Subject: New comments for application 19/01037/REM

Application Numbers: 19/01037/REM and 19/00895/REM

Reserved matters to 15/01326/OUT - Layout, scale, appearance and landscaping for the residential development of up to 280 dwellings and 34 space car park.

OS Parcels 6741 and 5426, West of Cricket Field Nor Wykham Lane, Bodicote

Drawing Title
HARD, BOUNDARY & FURNITURE PROPOSALS (SHEET 2 OF 3)

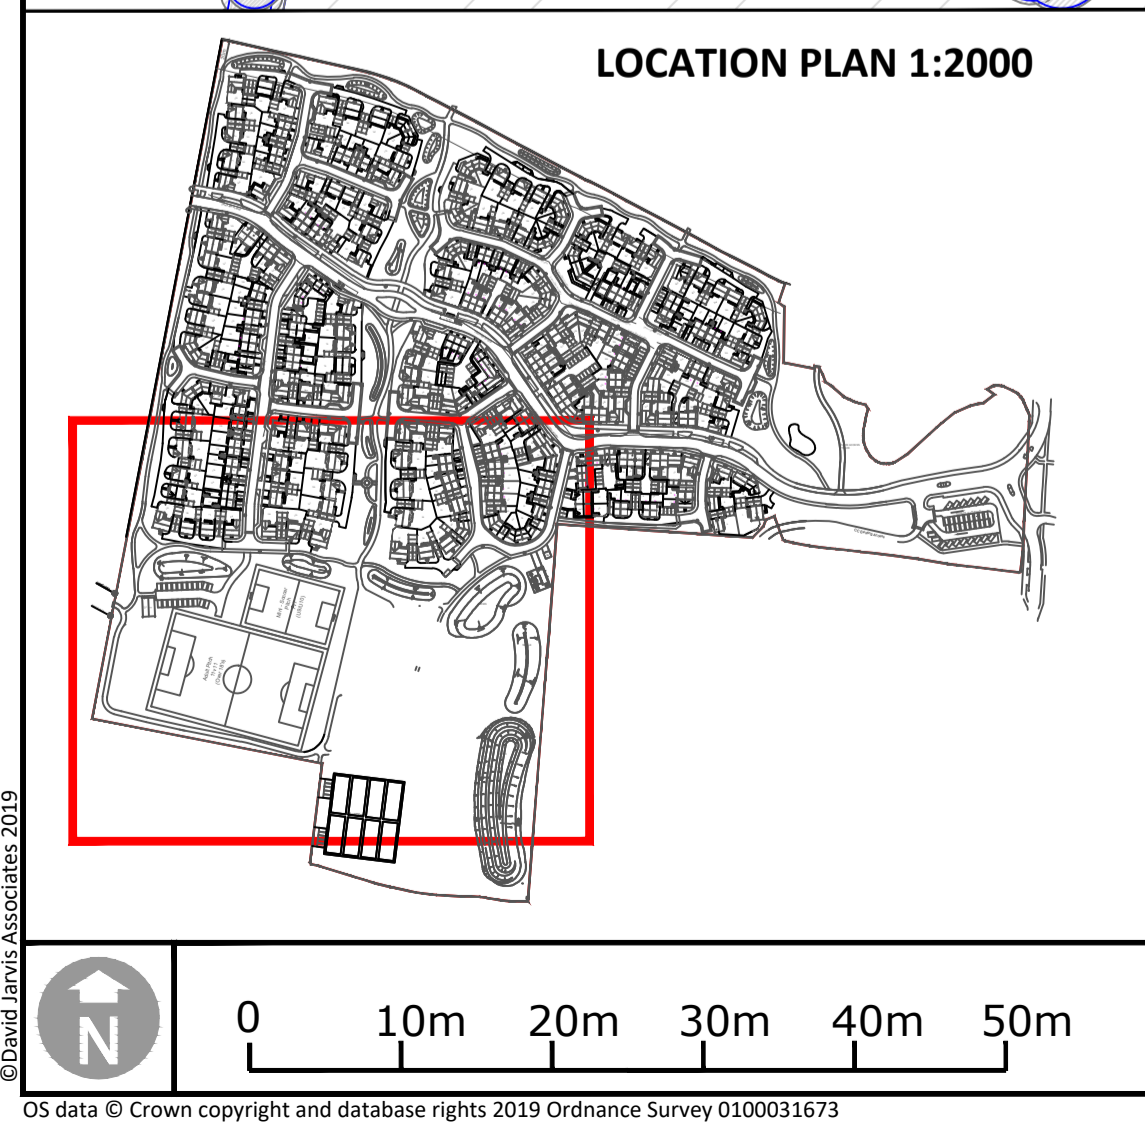
Bins are included on both layout proposals for the Central and Western Play Areas, totalling in three for the entire development. Are there plans to include additional bins near bus stops, bridleways, pitches or green open spaces?

When will bins be provided for resident use and who will be responsible for maintaining them? We are aware of existing issues regarding litter and dog faeces on the Longford Park development, due to a lack of bin provision, and would not want that replicated.
